FAO: George Harrold (Case Manager)
 24 August 2023

Application for a development consent order by Gatwick Airport Limited for the Gatwick Airport Northern Runway project (Ref. TR020005) – Response to advice received from the Planning Inspectorate under section 51 of the Planning Act 2008

Title: **Traffic Regulation Plans Classification of Roads APFP Regulations 5(2)(o) Sheet 1A - Proposed Measures**

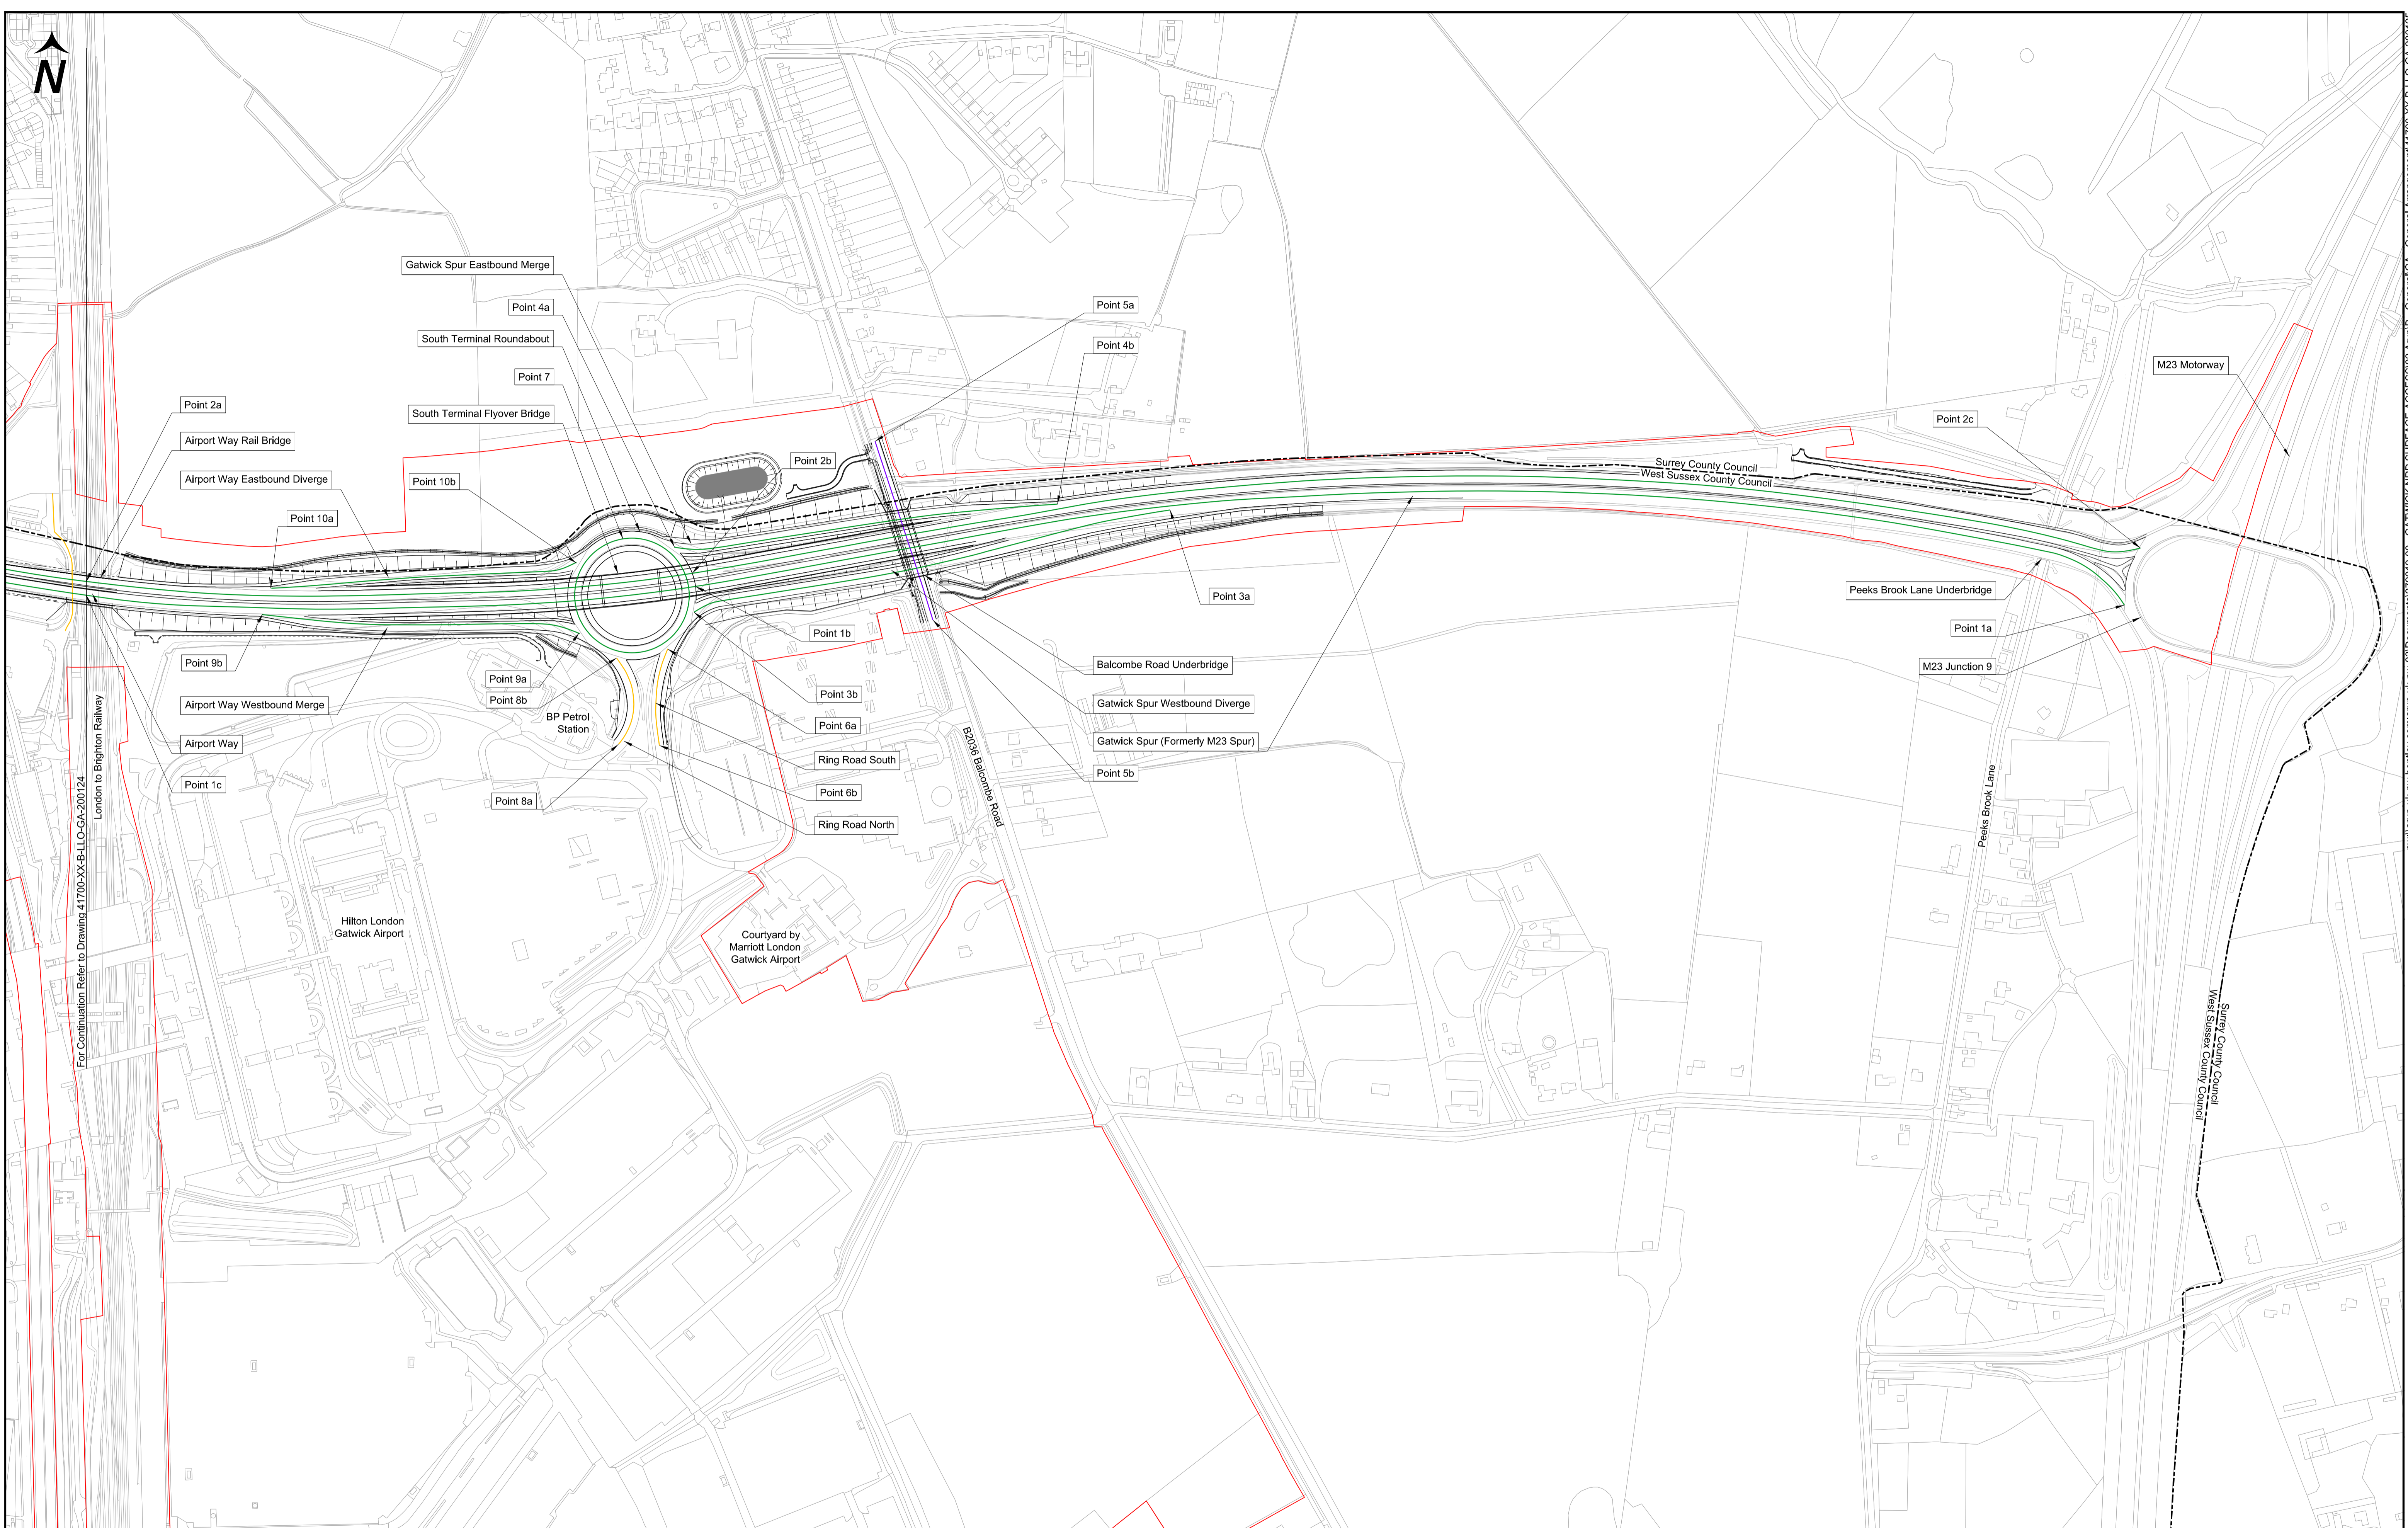
| Updated | Traffic Regulation Plans – Classification of Roads (Doc Ref. 4.9.2 v2) | To amend the omission identified within Box 30 of the section 55 checklist on Sheet 1A of the Classification of Roads plans. |
